Our Ref: MAAG0005110
LETT0003330

Maxwell Underground Coal Mine (SSD-9526): Response to Submissions

I refer to the correspondence dated 22 November 2019 inviting the Resources Regulator to review the Response to Submissions for the **Maxwell Underground Coal Mine SSD-9526**.

Figure 7-1

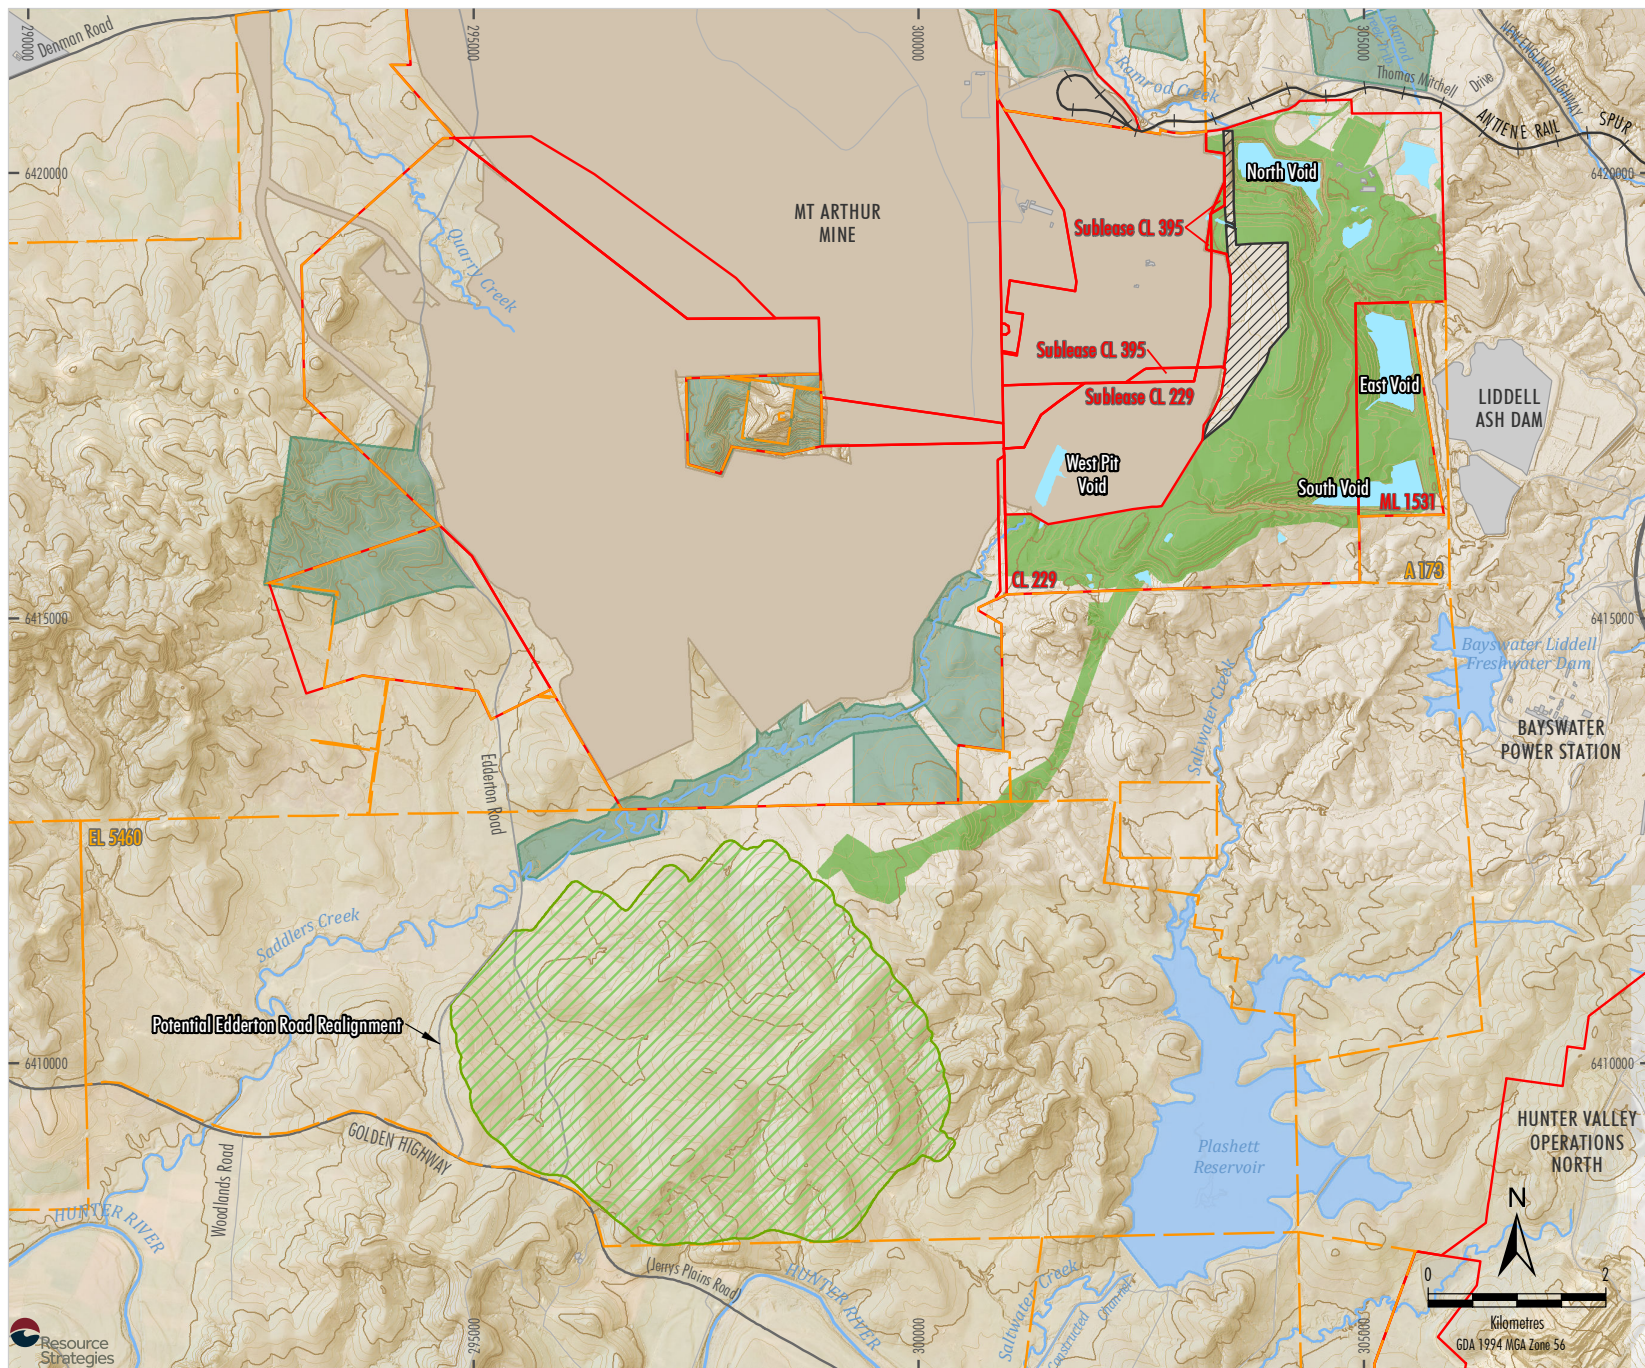
- The Response to Submissions outlines that if no clear resolution to reduce the size of voids is reached by 2025 in relation to options for additional emplacement of rejects or overburden/interburden, Malabar would rehabilitate the South Void highwall and North Void low wall in accordance with the Final Void Management Plan (FVMP). As the FVMP has been incorporated in the approved Mining Operations Plan under the condition of the mining leases, the Regulator considers that the rehabilitation commitments for the final voids as outlined in this document should be included into the Environmental Impact Statement;

- Rehabilitation objectives need to be more specific to clarify outcomes in relation to the following:
 - the target capability of the land that will be returned to pasture (e.g. land capability classification); and

- the target woodland communities that revegetation activities will be designed to achieve on site. Given the age of the existing rehabilitation areas, it is noted that it will not be the intent to create like-for-like vegetation communities. However, specificity of target communities should be provided to ensure that the woodlands that are established on site are consistent with local vegetation communities in terms of species composition as well as habitat value.

Figure 7-2

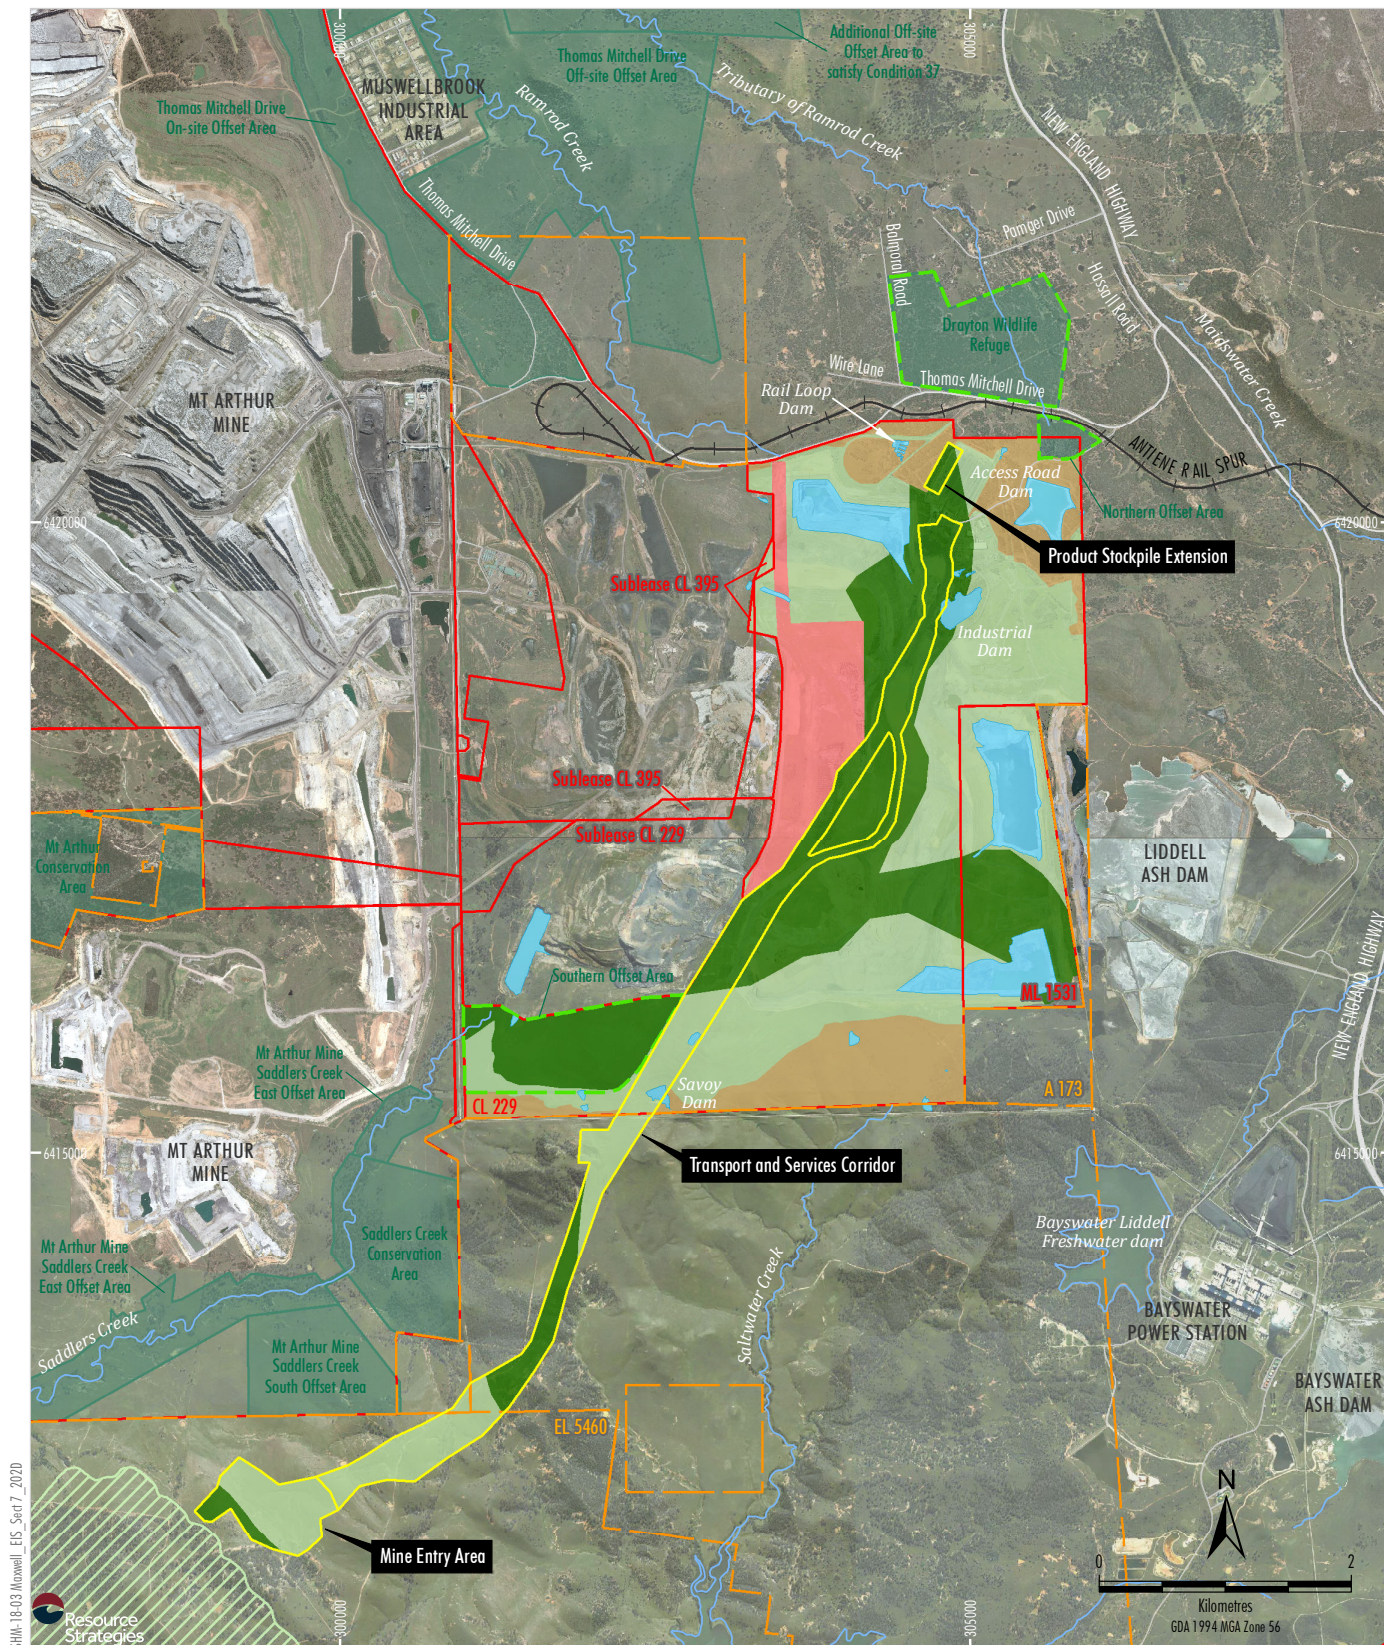
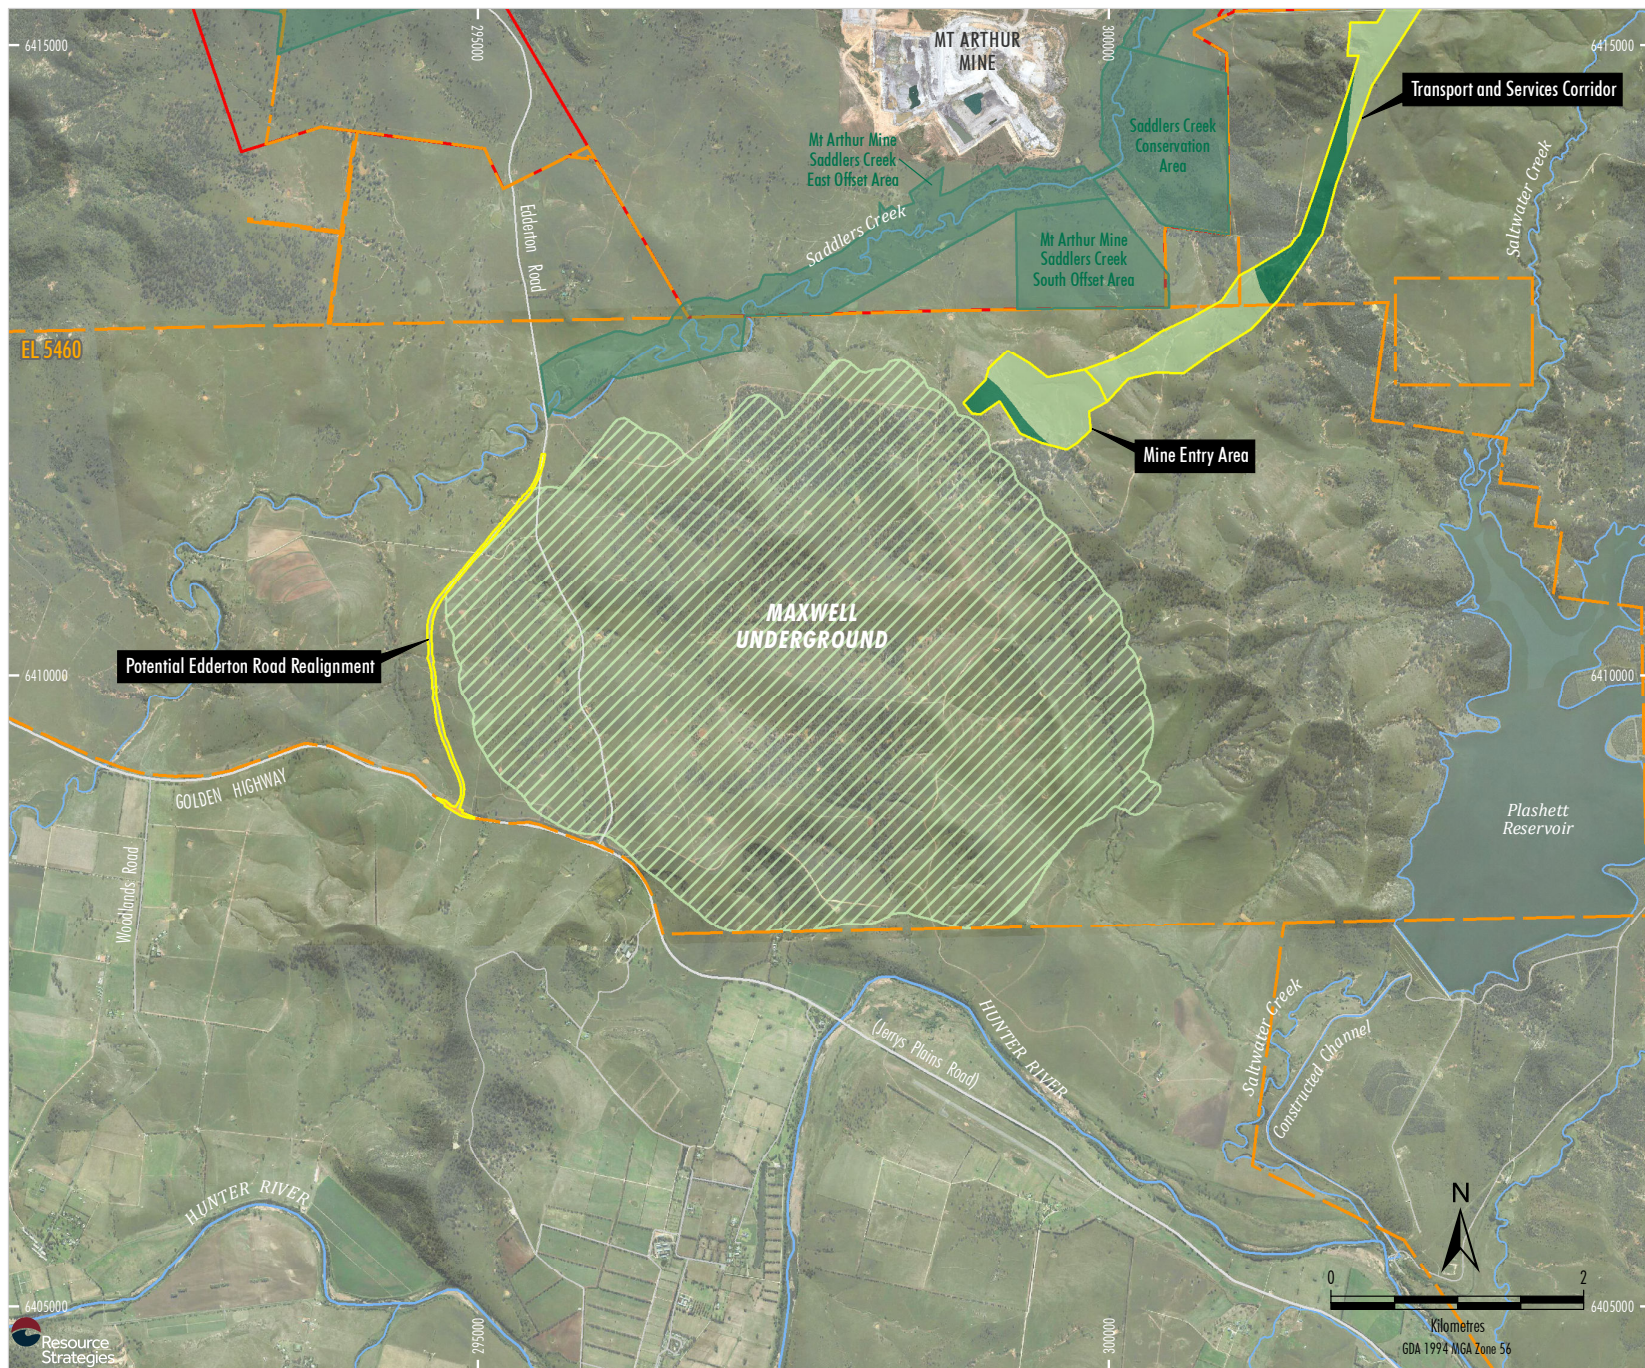
- Malabar has included objectives for the Maxwell Solar Farm Infrastructure Area. As this project does not have a current development consent, the Regulator is of the view that the rehabilitation obligations under the existing consent will continue to apply. A change in the rehabilitation obligation for this area will be dependent upon whether a development approval is granted for the solar project.
